Ribchester Parish Council

PLANNING APPLICATION No: 3/12/0294 and 295

Application: Proposed demolition of single storey extension to be replaced with a two storey extension [resubmission]

At: 12 & 13 MANOR AVE. RIBCHESTER

Proposed Ground Floor Layout

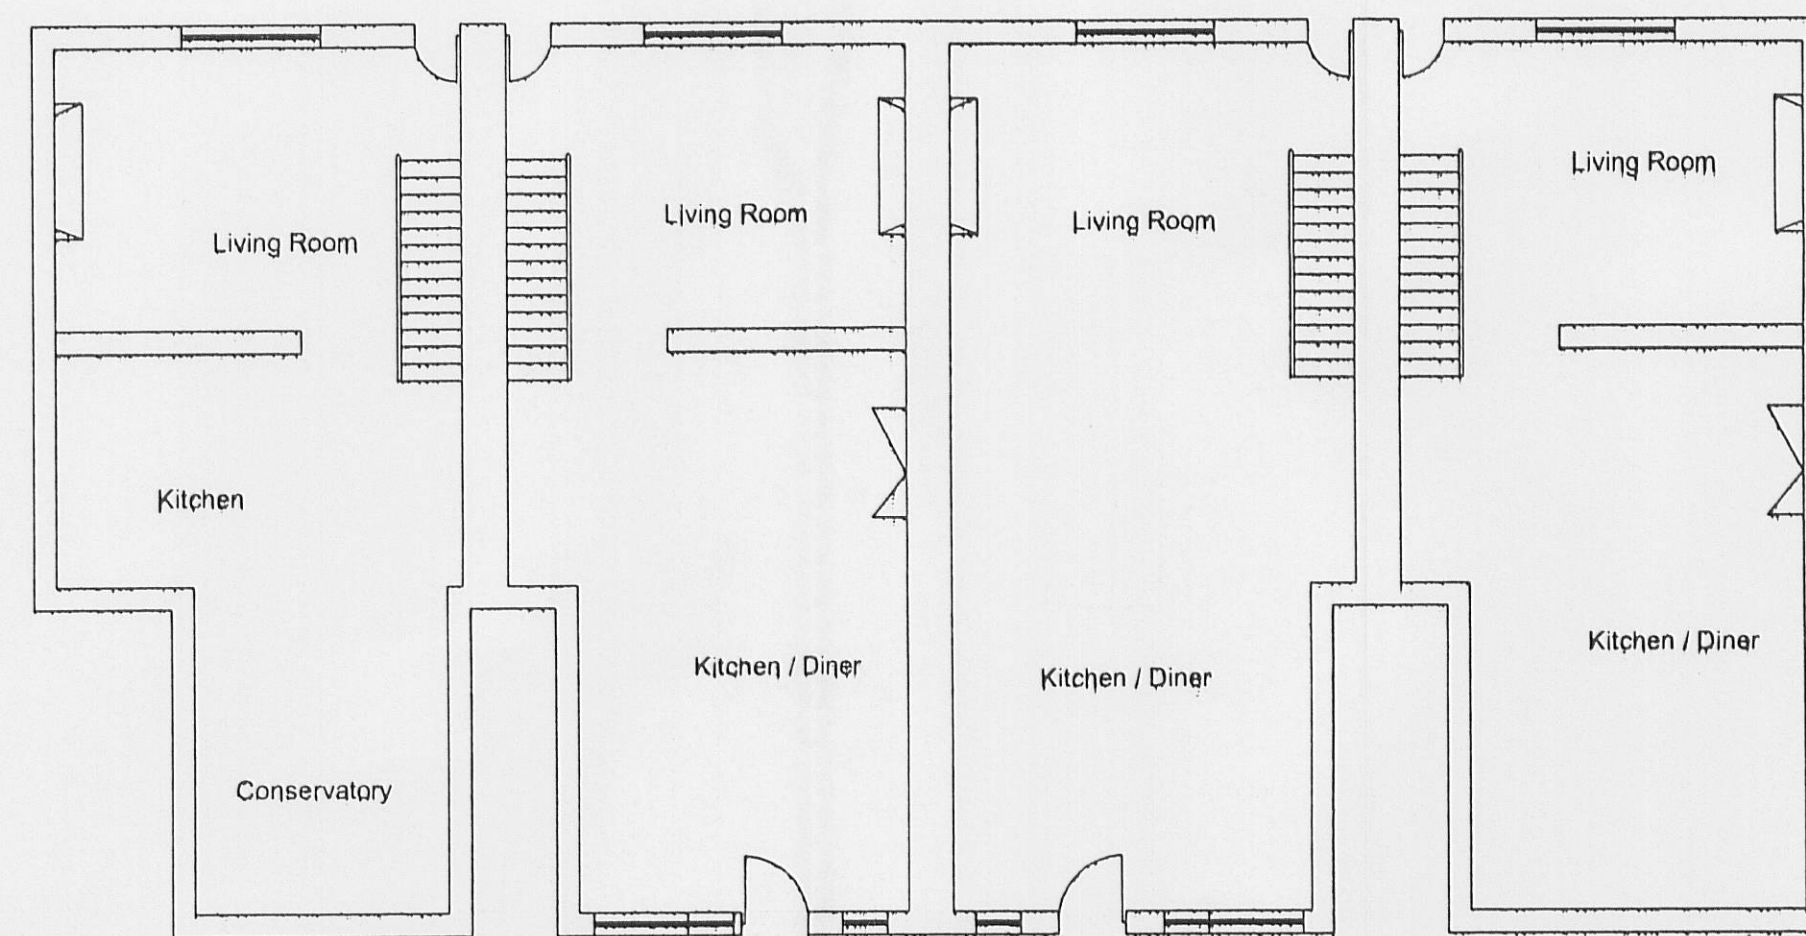
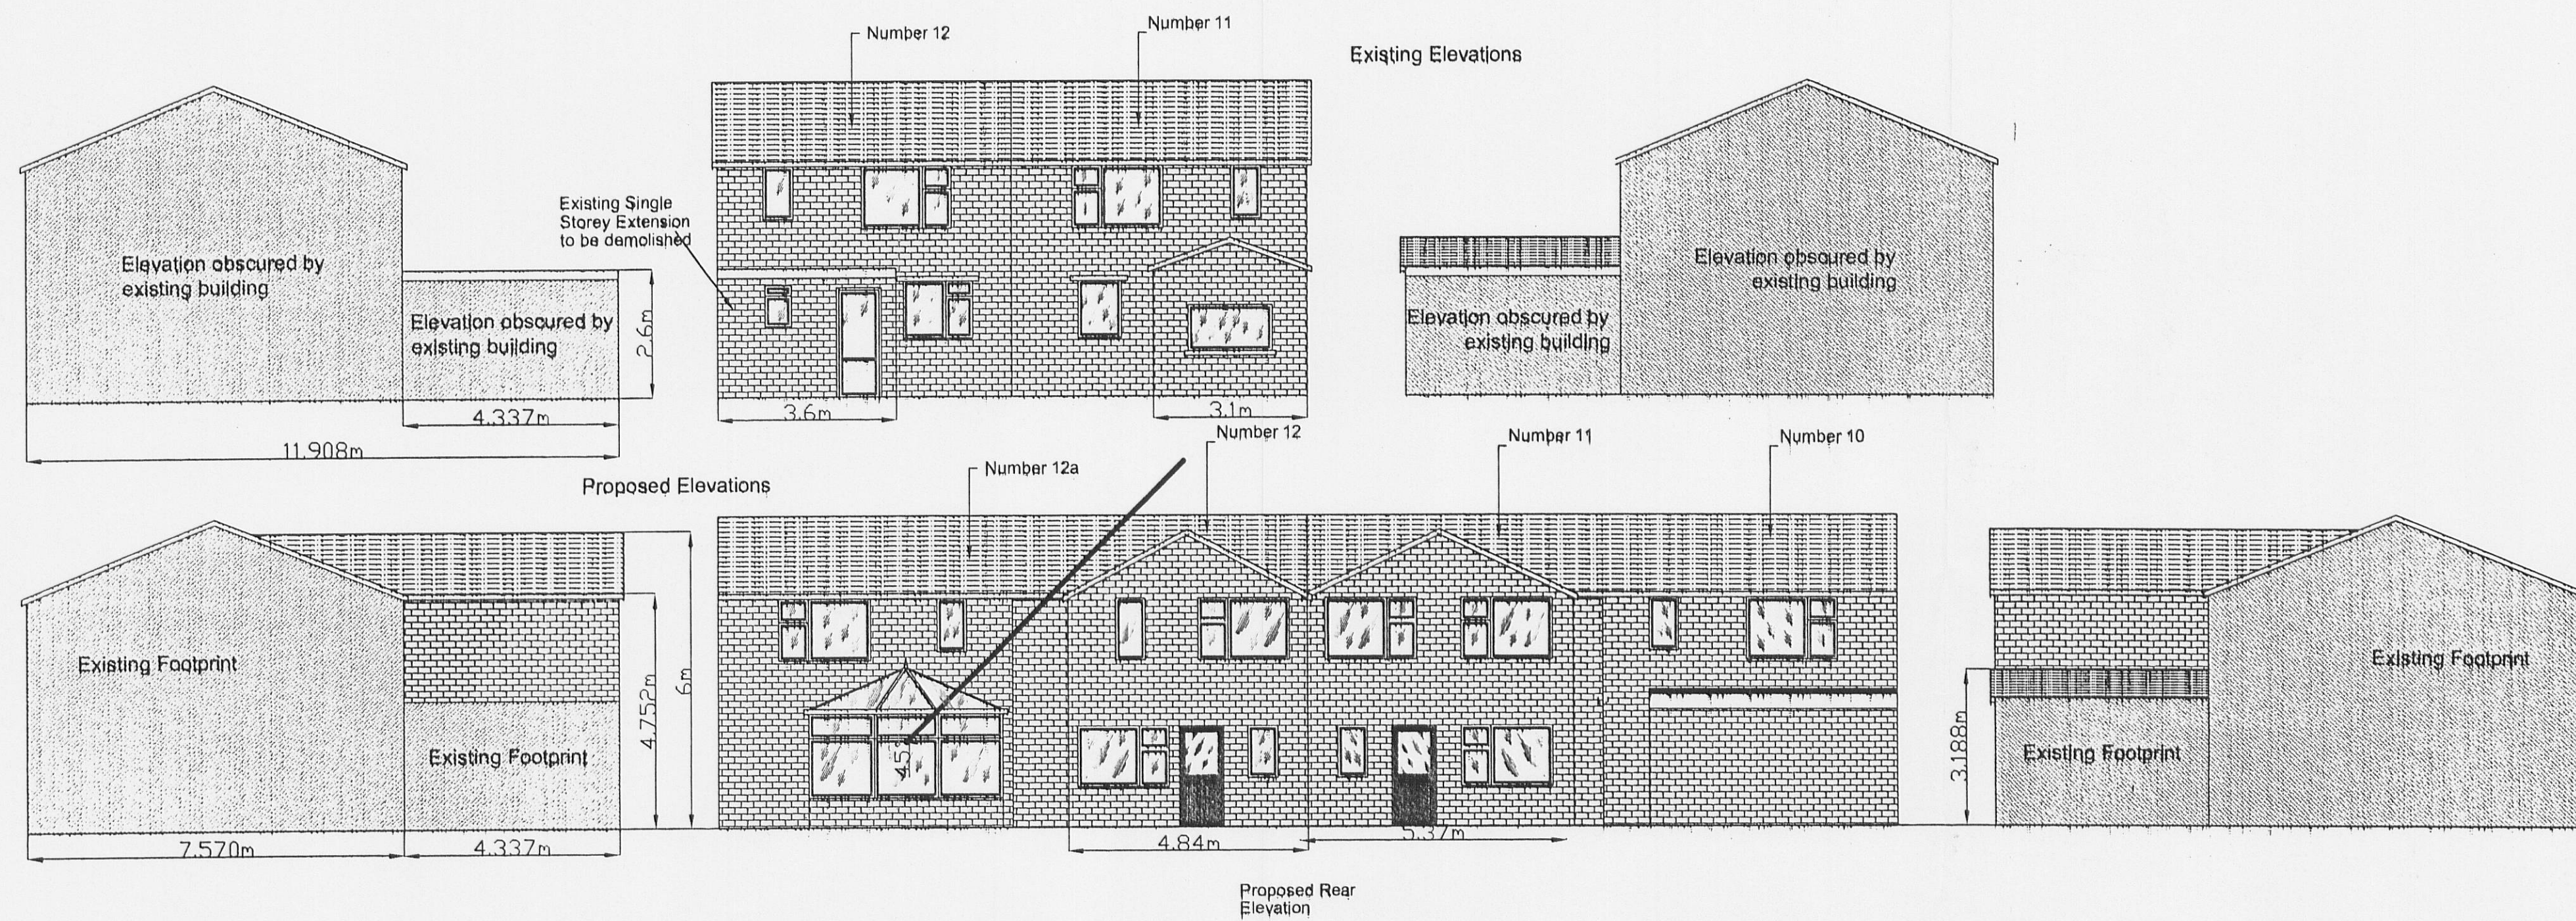
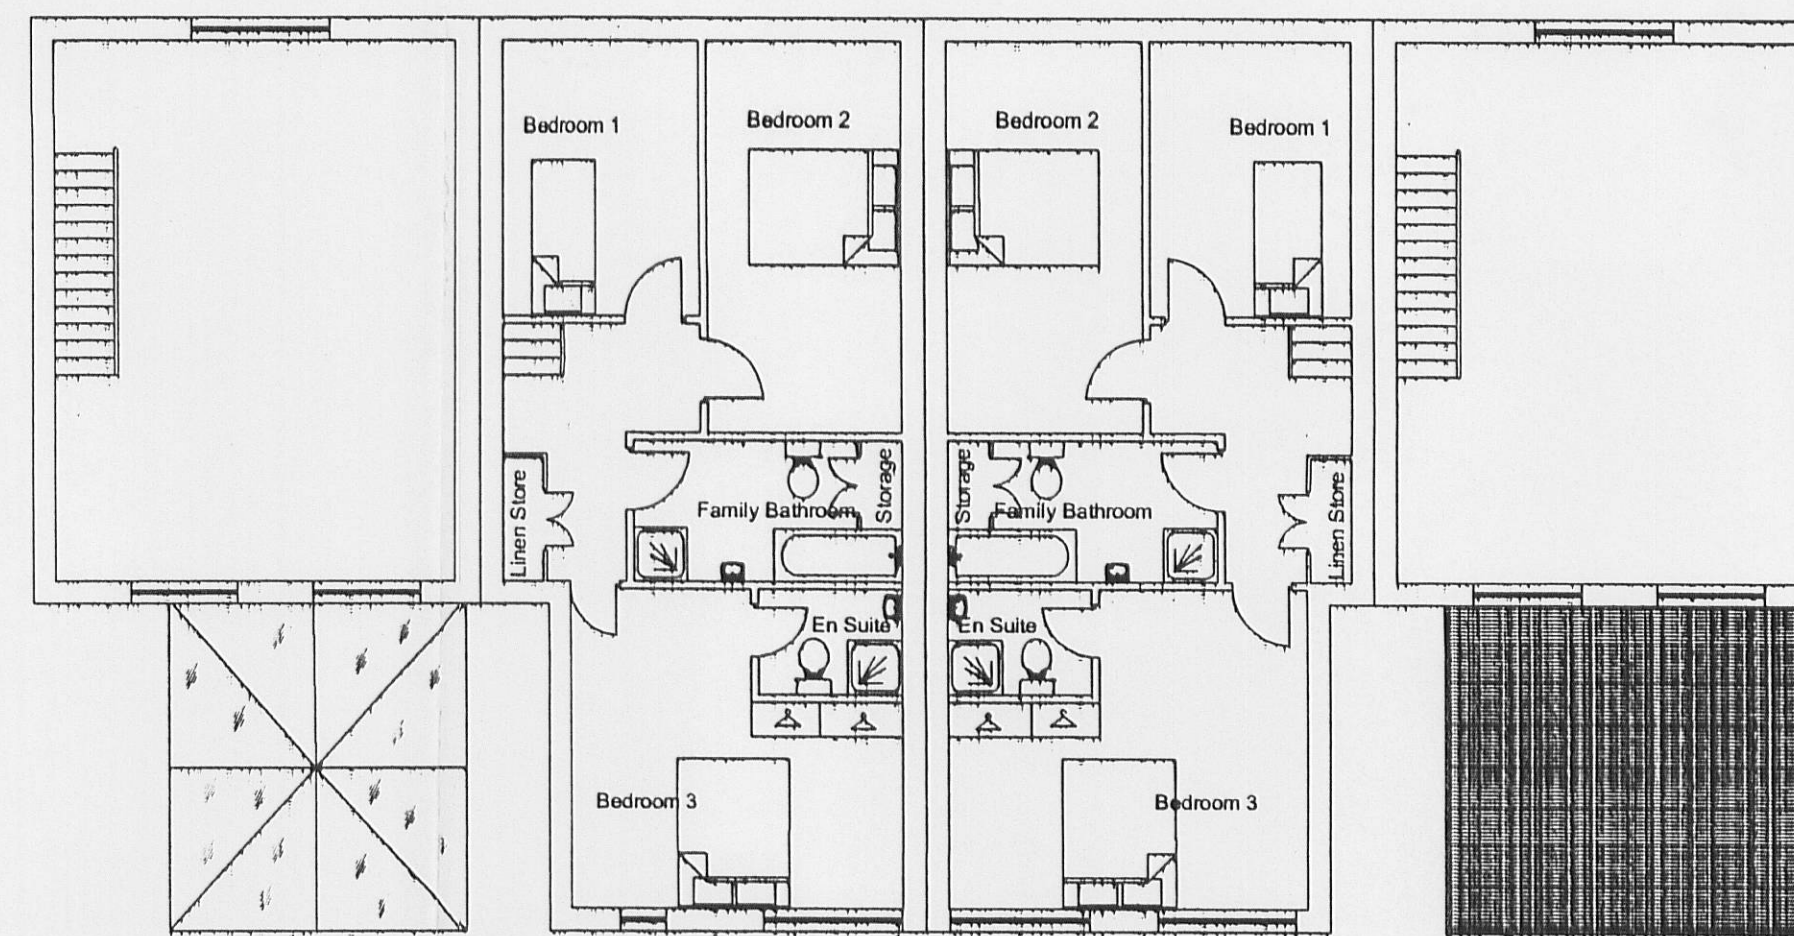
The Parish Council notes that the two original applications were refused by planning officers on the grounds that the proposals were harmful to the amenity of neighbouring residents as a result of the overbearing nature of the developments and the loss of light. The present applications as now submitted show such minimal adjustments to dimensions that the initial conclusion remains pertinent.

While the Parish Council did not object to the original applications it now takes the view that the proposals would result in significant harm to the amenity of neighbouring properties and, therefore OBJECTS to the applications.
